Your Ref
EG/70/18/HH
Our Ref
PLAN-0025165
Date
13/11/2018

Proposal: Two storey rear & single storey side extensions.
Site: 23 Elm Grove, South Barnham, PO22 0EJ.
EG/70/18/HH

Roof Plan

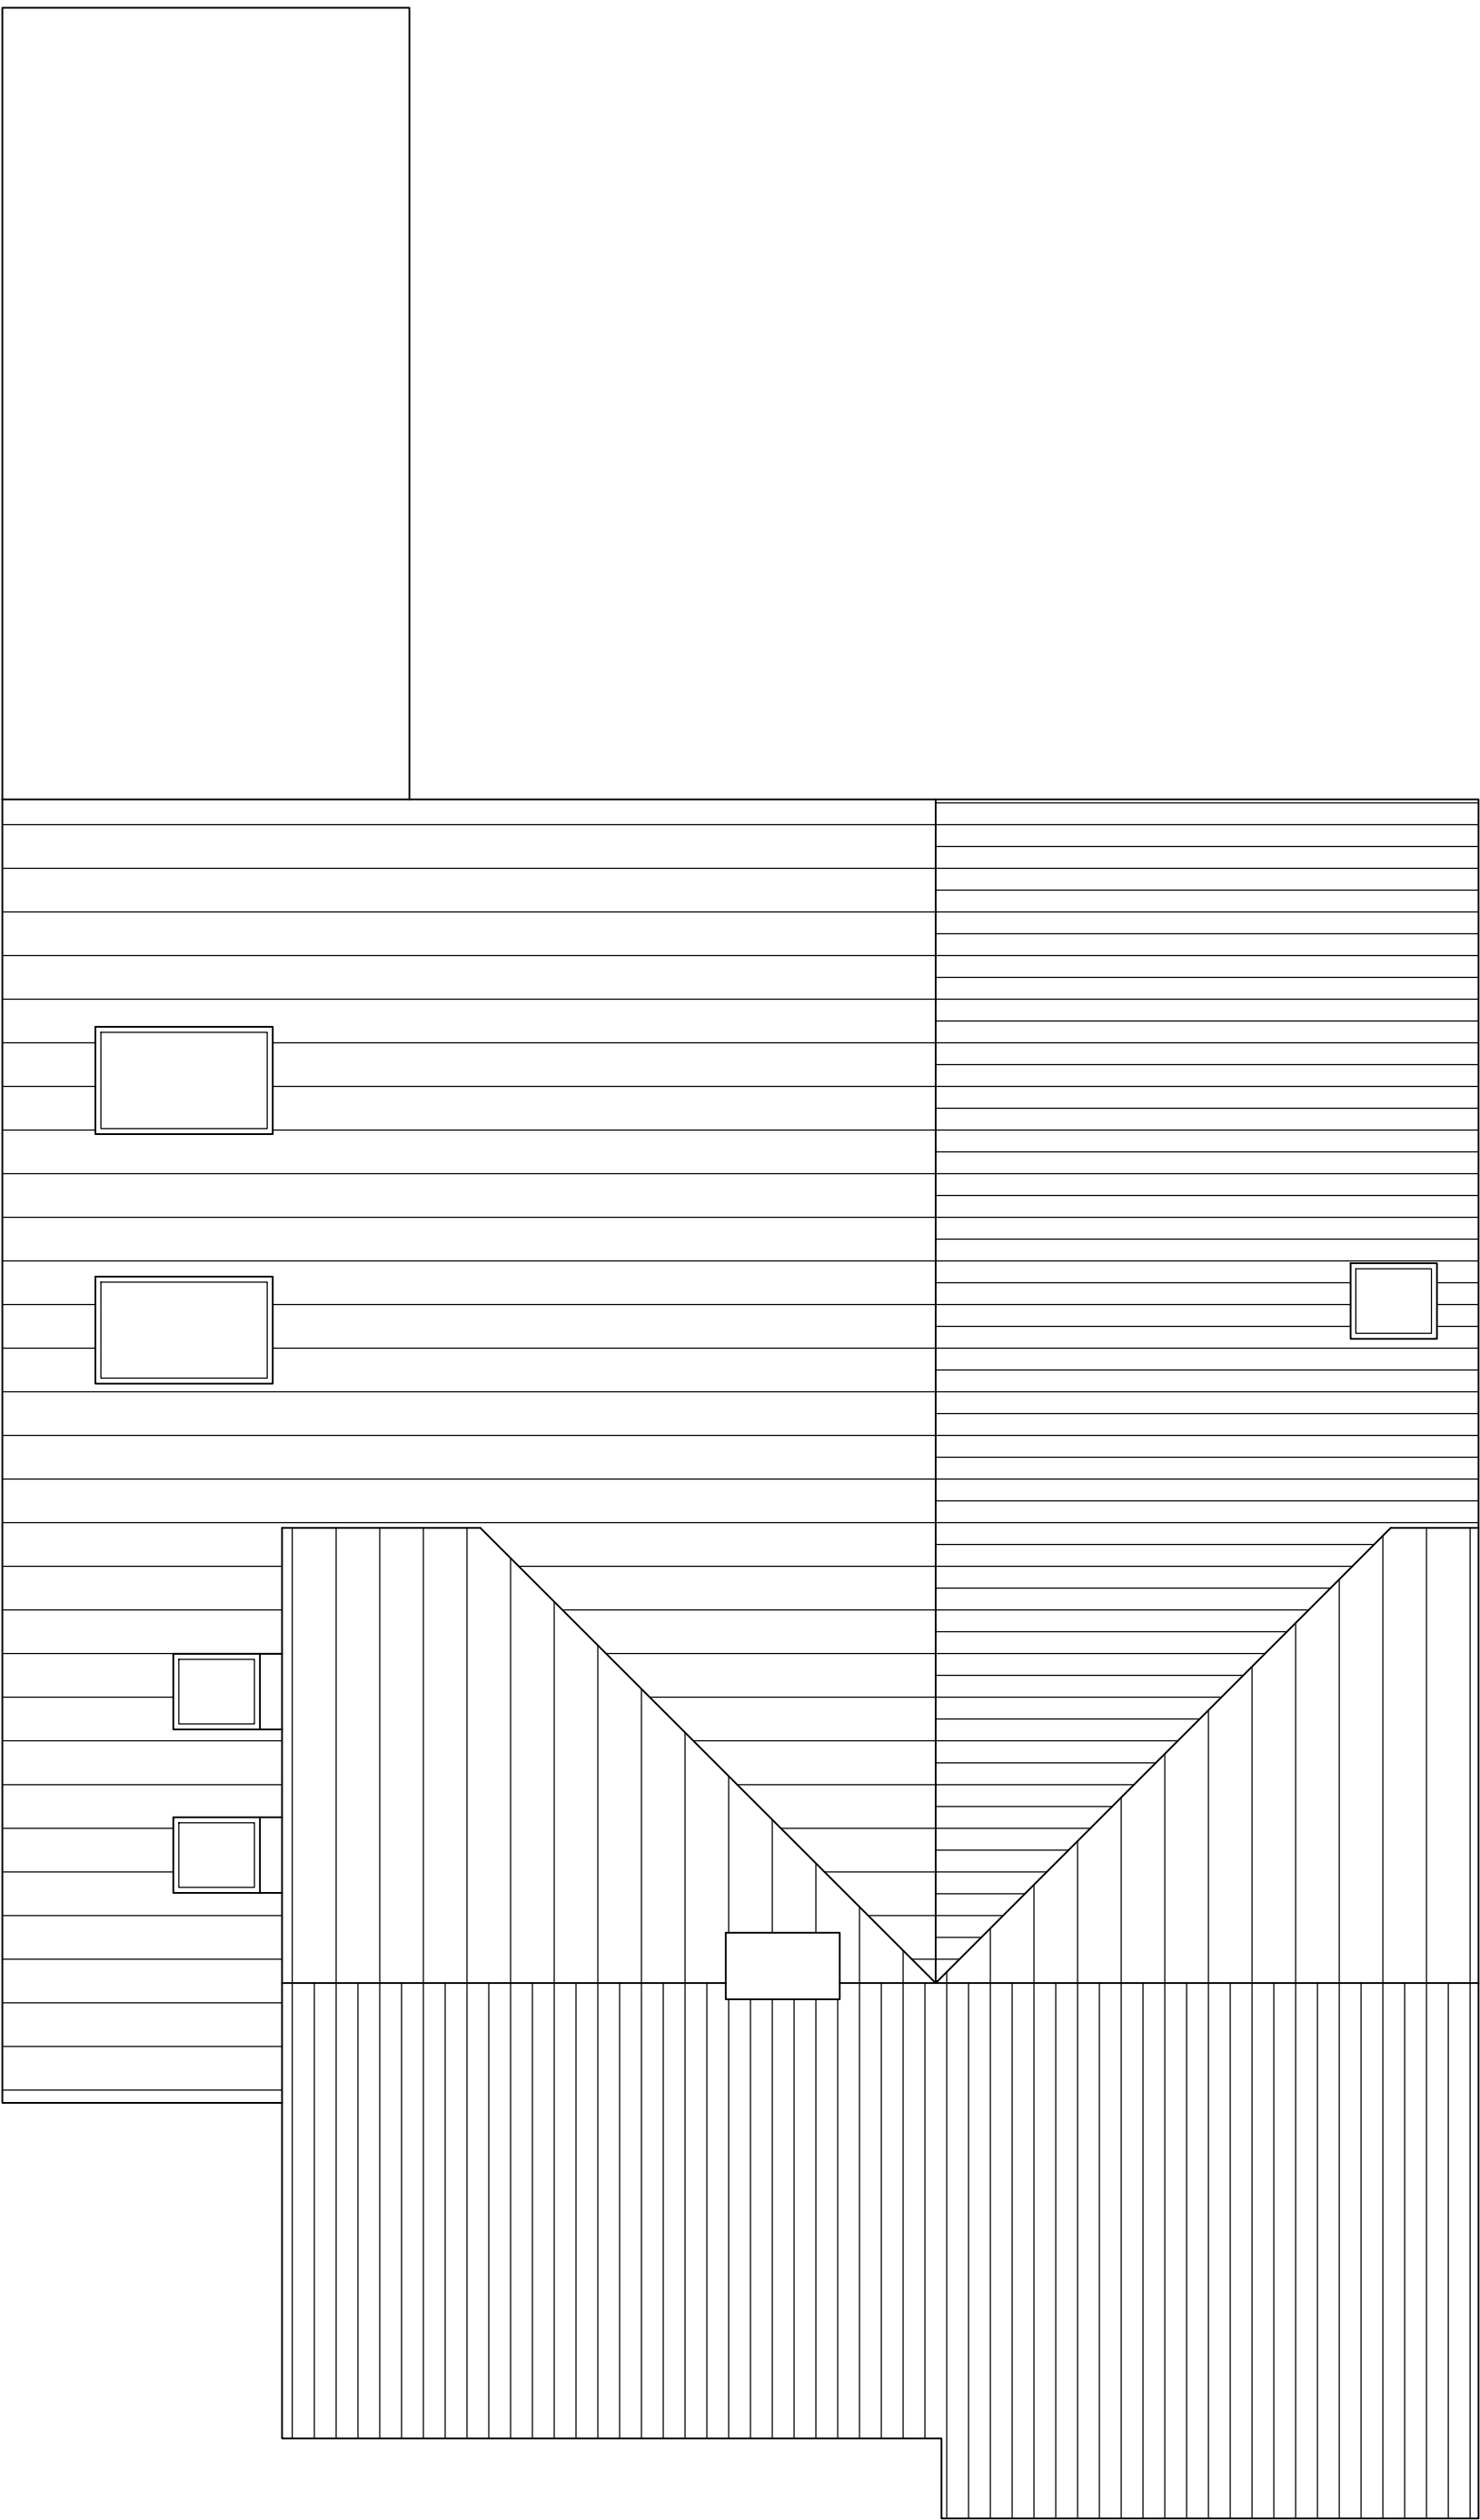
The submitted plan, drawing number 03 Rev C, shows a public sewer within the site not shown on records. It appears that the developer is intending to build close to a public sewer. Building over a "public sewer" is not normally permitted by Southern Water. An investigation of the sewer is required to ascertain its condition, the number of properties served, and potential means of access, before any decision can be made as to whether it would be acceptable for the proposed development to be built close to the sewer. Part H of the Building Regulations dictates that the matter is determined by the sewerage undertaker – in this case Southern Water.

In order to protect drainage apparatus, Southern Water requests that if consent is granted, a condition is attached to the planning permission For example: "The developer must agree with Southern Water, prior to commencement of the development, the measures to be undertaken to protect the public sewer."
